May 22, 2019

RE: Monument Steel Structures

18910 Base Camp Road
Monument, CO 80132
Tax Schedule No.: 7111303005
Zoning: Commercial Community (CC)

After reviewing the documents, the District has the following concerns and/or recommendations:

SITE DEVELOPMENT PLAN
MONUMENT STEEL STRUCTURES
 SITE AND UTILITY PLAN
 18910 BASE CAMP ROAD
 MONUMENT, COLORADO

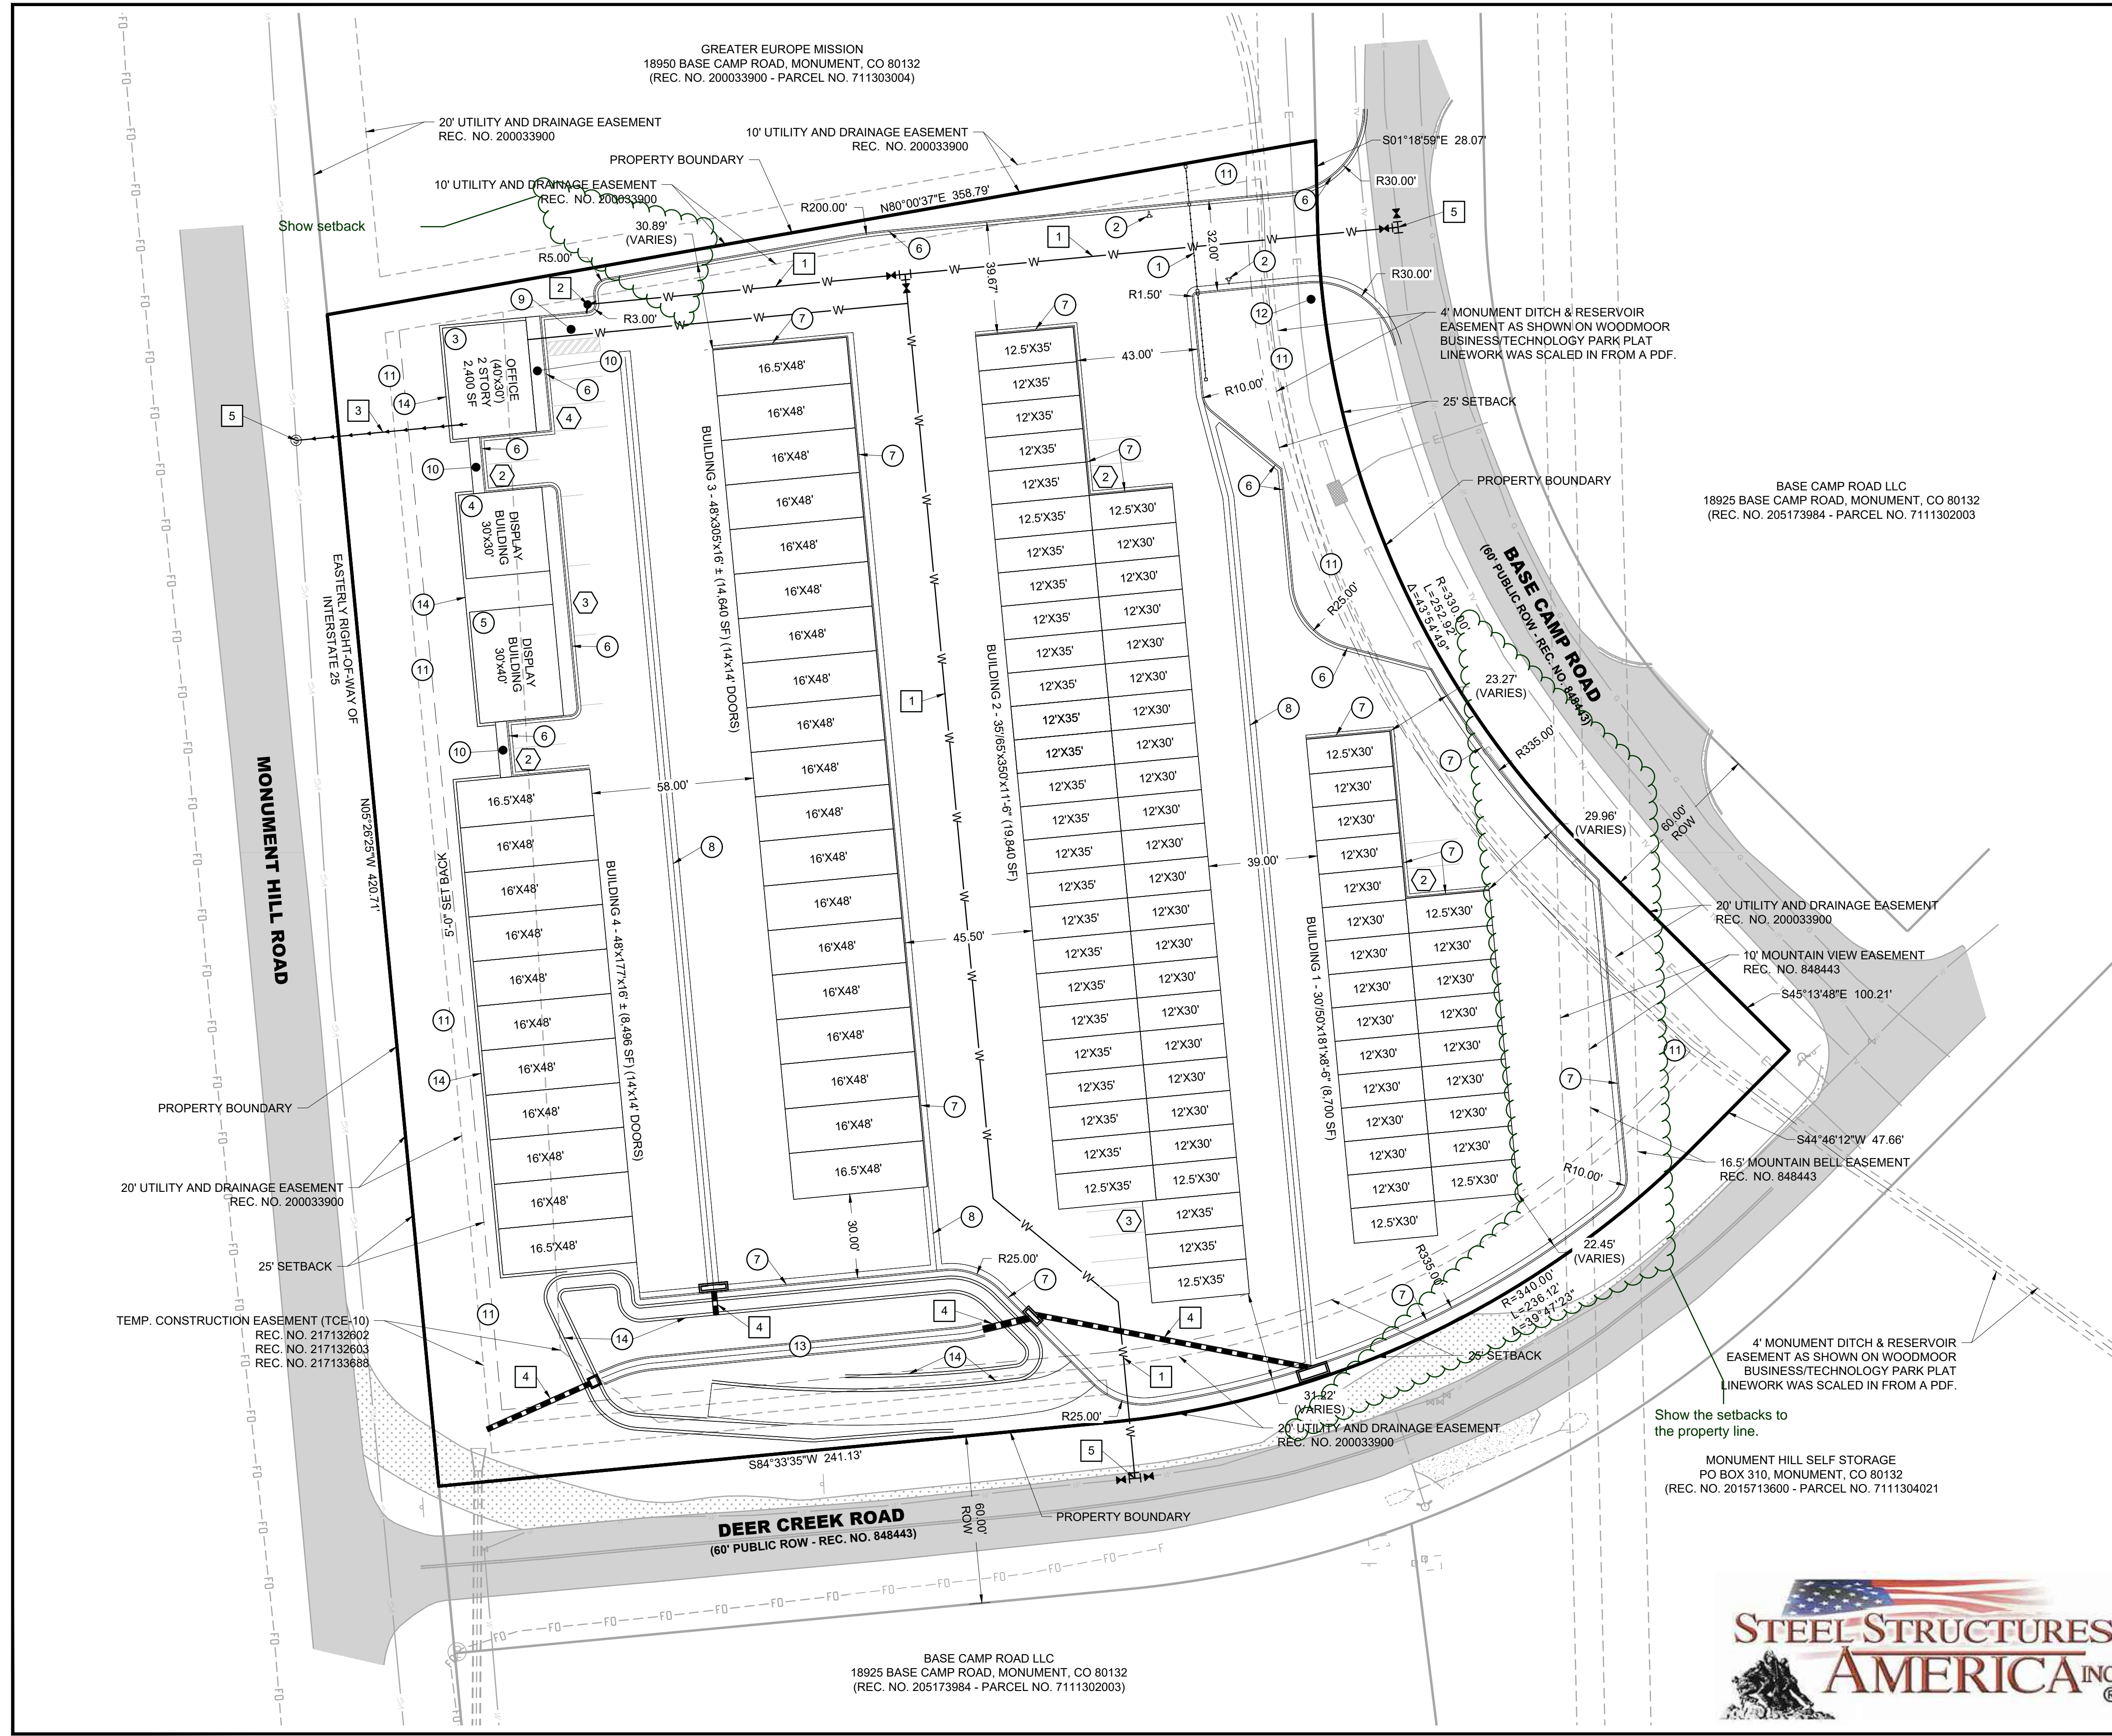
3. The Site and Utility Plan shows a looped water system through the property. The District and Terra Forma held preliminary discussions in September of 2018 to discuss the layout of the water service lines and fire hydrant locations. The water system loop line (from Deer Creek Road north into the development) was discussed as a potential requirement if 2 or more hydrants were to be installed in order to maintain maximum allowable fire hydrant spacing (assumed to be 500 feet) per the Tri Lakes Monument Fire Protection District (TLMFPD). However, only one proposed fire hydrant is shown on the plan. We presume the need for only one proposed fire hydrant was dependent upon its proximity to the existing hydrant located at the northwest corner of the intersection of Base Camp Road and Deer Creek Road in conjunction with TLMFPD requirements. Provided only 1 hydrant is to be installed, the District does not require that a looped system be provided. A minimum 20' easement will be required to be conveyed to the District, on the Districts standard form, for any main extensions to be constructed.

4. The Site and Utility Plan shows the water service line connecting to the proposed looped water main through the property. As discussed in item 3 above, the District does not require the proposed looped system and therefore connecting the water service line directly to the water main located in Base Camp Road would be the preferred service line routing. Revise as required. In addition, please show/note the location of the water curb stop box. Curb stop boxes may be placed near the property boundary but outside of any fenced area to allow for District access or they may be placed within the property boundary centered in a minimum 20' easement legally conveyed to the District on its standard form together with proper gate access (gate code, knox box access, etc.) provided to the District.

5. All commercial structures served with sanitary sewer are required to install a monitoring manhole (minimum size - 4 foot ID) on the sanitary sewer service line. This is in addition to any service line clean outs that may be installed. Please show/note the location of the monitoring manhole to be installed on the sewer service line. Monitoring manholes may be placed near the property boundary but outside of any fenced area to allow for District access or they may

be placed within the property boundary suitably situated centered in a minimum 20' easement legally conveyed to the District on its standard form together with proper gate access (gate code, Knox box access, etc.) provided to the District.

6. Please note that the District requires access to the curb stop box and monitoring manhole, however sanitary sewer service lines (from the main to the customer's point of service) and water service lines (from and including the curb stop box to the point of service) are owned, operated and maintained by the customer.
7. If the landscaping shown will be served by an irrigation system, please show or note how the irrigation system will be served (i.e. separate tap and metering vault, tee from the office building plumbing, etc.).
